**Project# 1010284 - 15DRB-70219 MINOR - PRELIMINARY/ FINAL PLAT APPROVAL**

**CITY OF ALBUQUERQUE  
PLANNING DEPARTMENT  
December 3, 2014  
DRB Comments**

**PROJECT # 1010284**

**RE: Lot 13 & 12, Block 33, Ridgecrest Addition**

PLAT FOR
LOT 13-A and LOT 13-B, BLOCK 33
RIDGECREST ADDITION
 within SEC.26, T.10N., R.3E., N.M.P.M.
 CITY OF ALBUQUERQUE
 BERNALILLO COUNTY, NEW MEXICO
 MAY, 2015

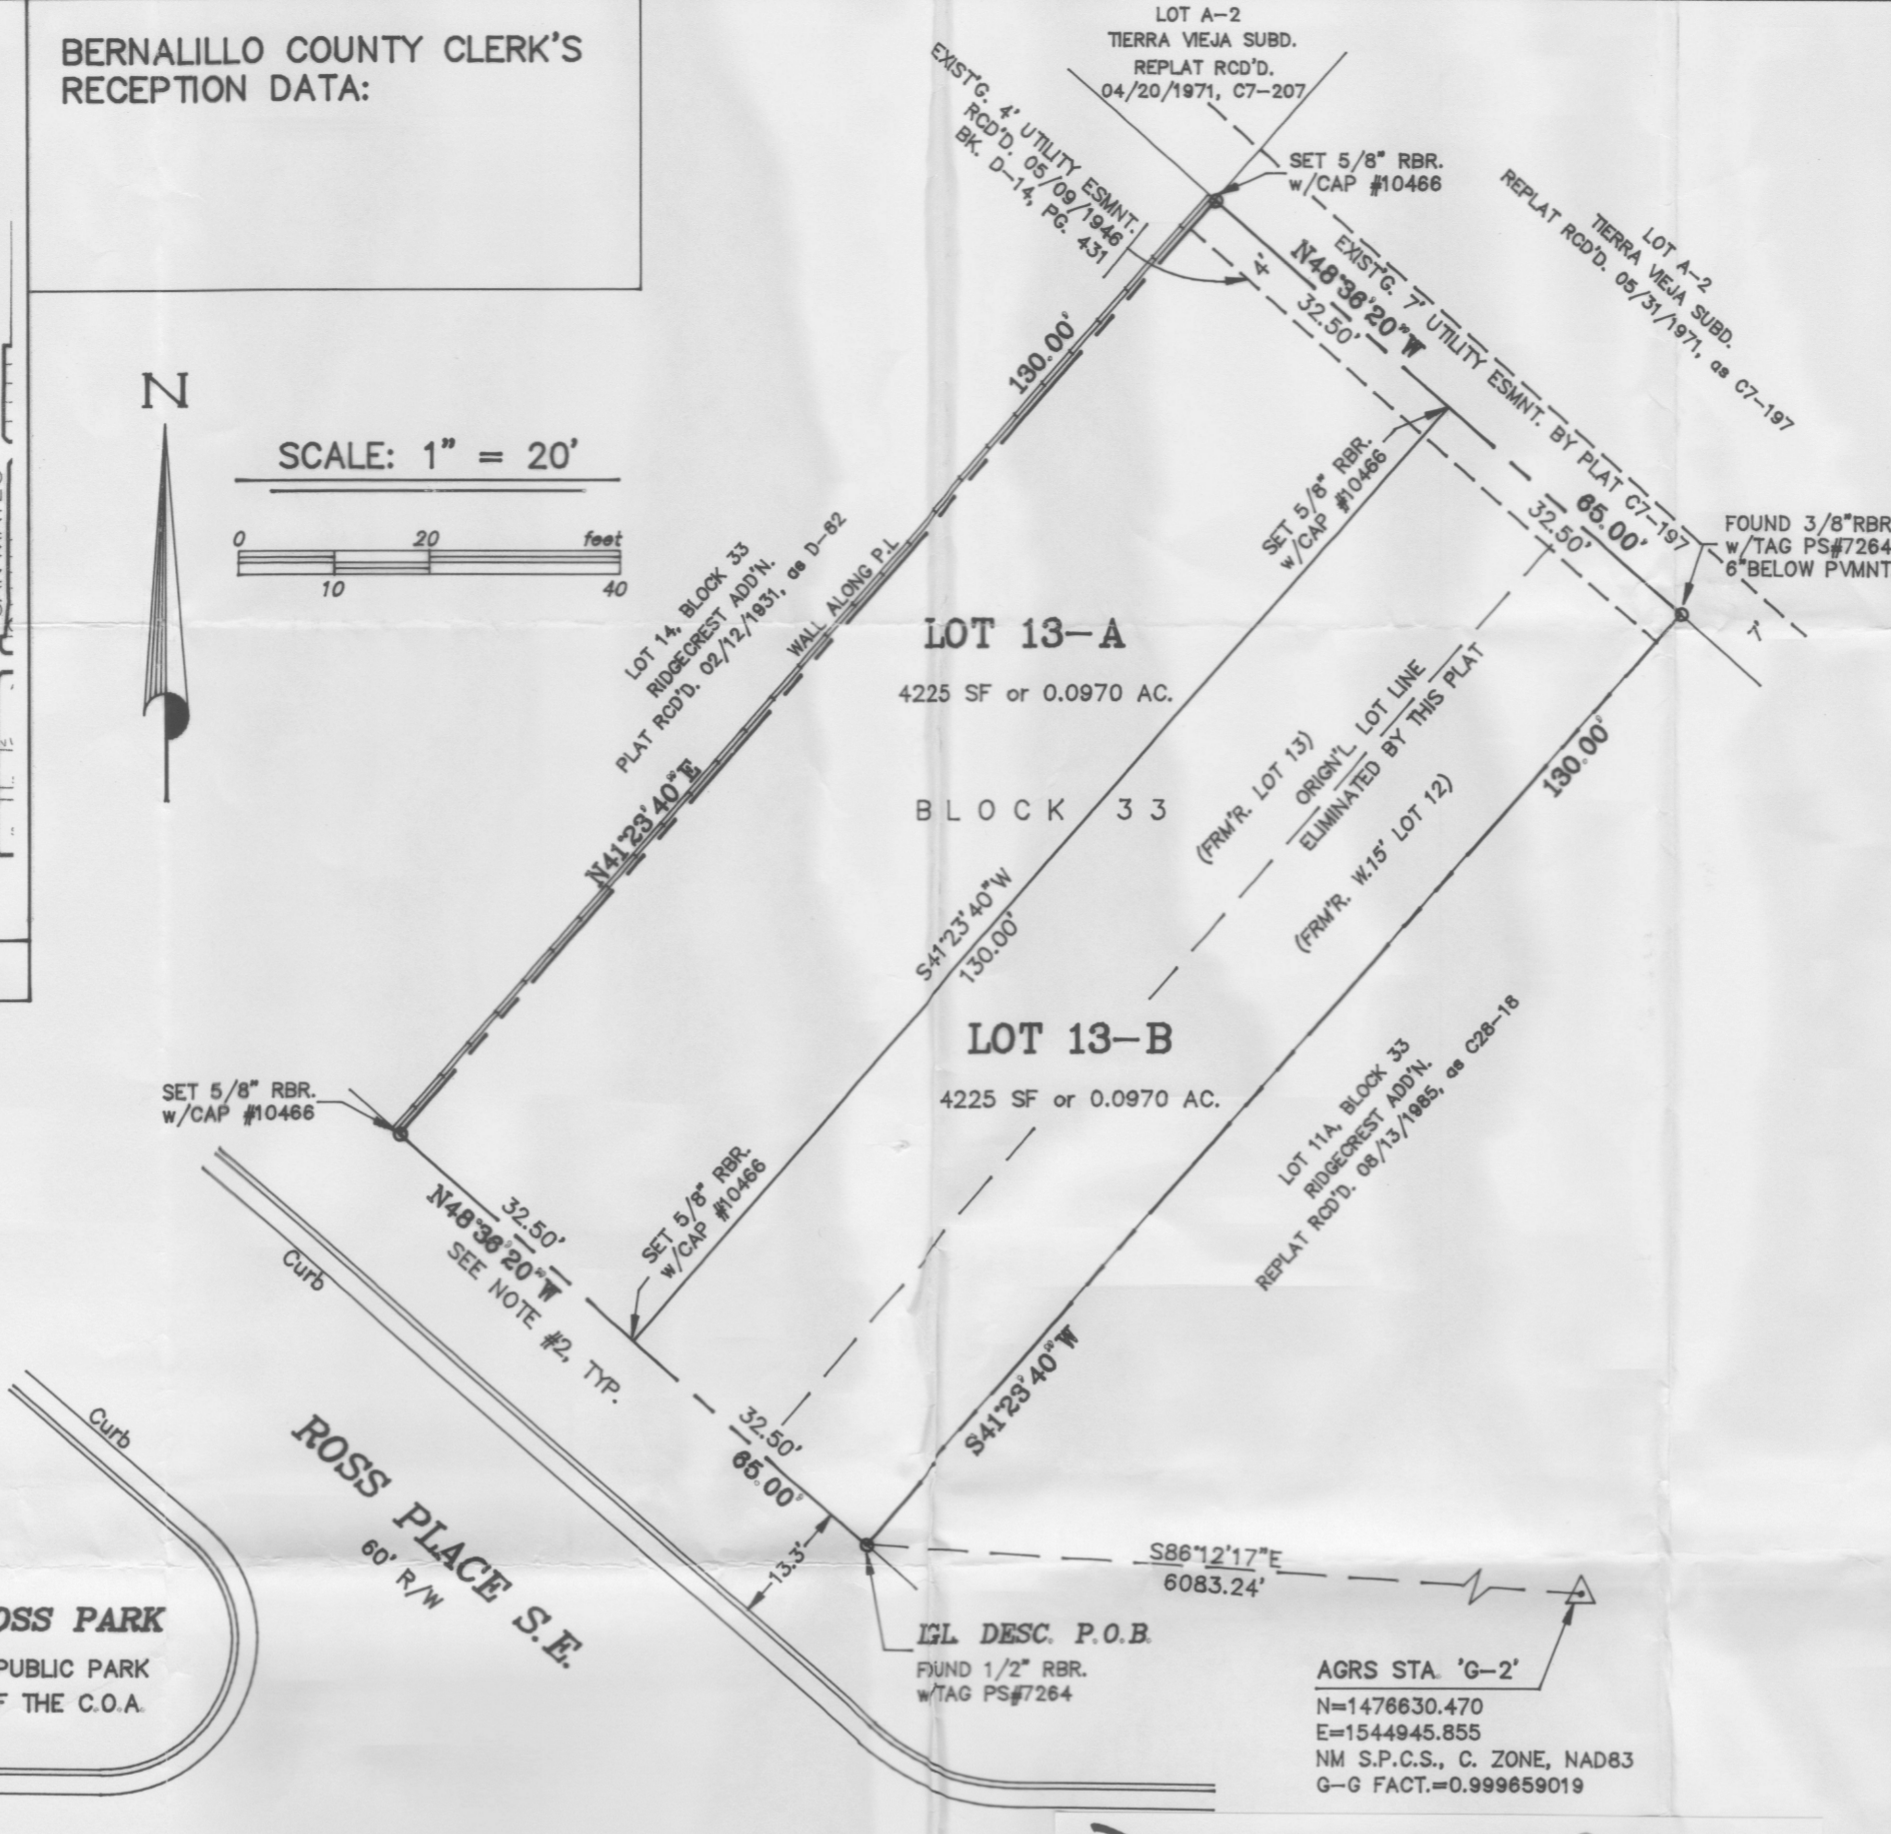
KRISTINA YU request(s) the above action(s) for all or a portion of Lot(s) 12, Block(s) 33, **TIERRA VIEJA** zoned R-2, located on ROSS PL SE BETWEEN CREST AV SE AND JACKSON ST SE containing approximately .19 acre(s). (L-17) **THE PRELIMINARY/FINAL PLAT WAS APPROVED WITH FINAL SIGN OFF DELEGATED TO WATER AUTHORITY OF THE ESTABLISHMENT OF SEPARATE WATER ACCOUNTS AND TO PLANNING FOR ADJOINER CORRECTION AND AGIS DXF, AS WELL AS A COPY OF THE 1960S DEED FOR THE PLANNING FILE.**

The "portion of" Lot 12 must be documented (by deed or other conveyance) prior to 1973 in order to conform to the current Subdivision Ordinance. Additionally, there is not a platted alley abutting this property; if there is an access agreement that goes with the deed or other conveyance it should be noted on the plat.
